Ribble Valley Borough Council
Housing & Development Control

Application no: **3/2021/0880**

Address: **Land adj Higher Parsonage Farm Parsonage Lane Chipping PR3
2NS**

Proposal: **Proposed siting of two camping pods including new access and
access road.**

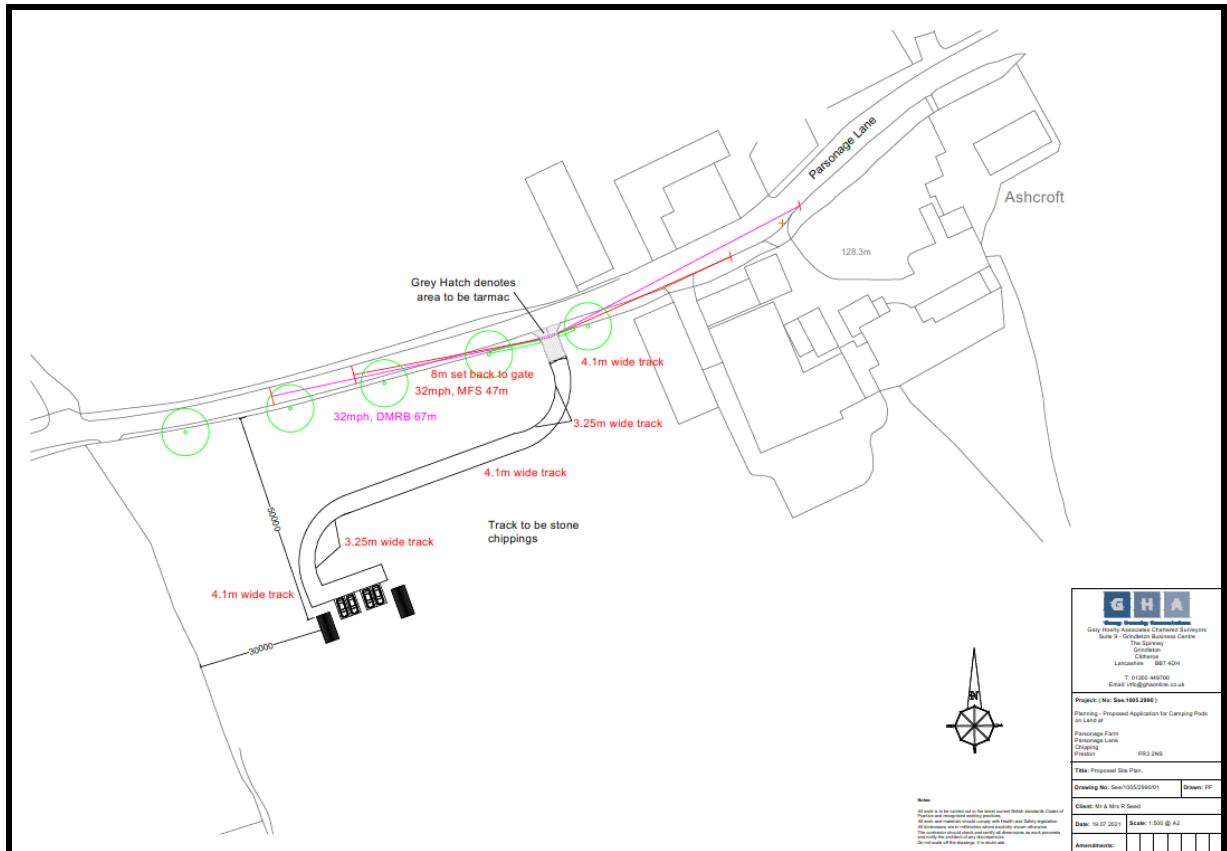
The LHA have reviewed GHA drawing number See/1005/2990/01 titled "Proposed Site Plan with Highways and Hedge Detail" and understands that the access width will be 4.1m wide.

For the siting of two holiday lodges, the LHA normally require the access width to be a minimum of 4.25m to comply with the LHAs guidance. However, in this case the LHA will accept the shortfall.

This is because, as stated in the Transport Statement, the Applicant did not want to conflict with the existing roots of the two trees either side of the proposed access. Conflicting with the roots could destabilise the tree which could be detrimental to highway safety. Therefore, this along with the proposal being classed as small scale, the LHA will accept the shortfall.

The LHA are also aware that the access will be gated. The setback distance of the gate from the public highway will be 8m which complies with the LHAs guidance.

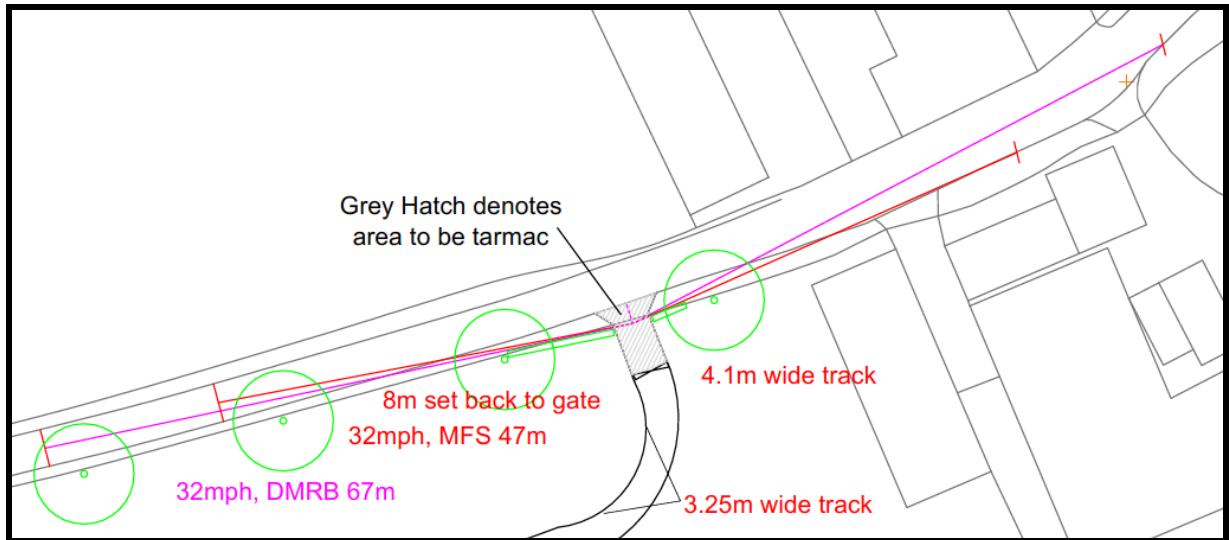
The speed survey data, which is found on the Local Planning Authorities website titled "Traffic Count," recorded 85th percentile speeds of 31.8mph east and 32.3mph to the west of the proposed access. This would mean that the LHA would require visibility splays of 2m x 47m to the left and 2m x 47m to the right of the access.

The Agent has provided GHA drawing number See/1005/2990/01 titled "Proposed Site Plan with Highways and Hedge Detail", which shows the access can achieve the minimum visibility splays and so the LHA have no further comments to make.
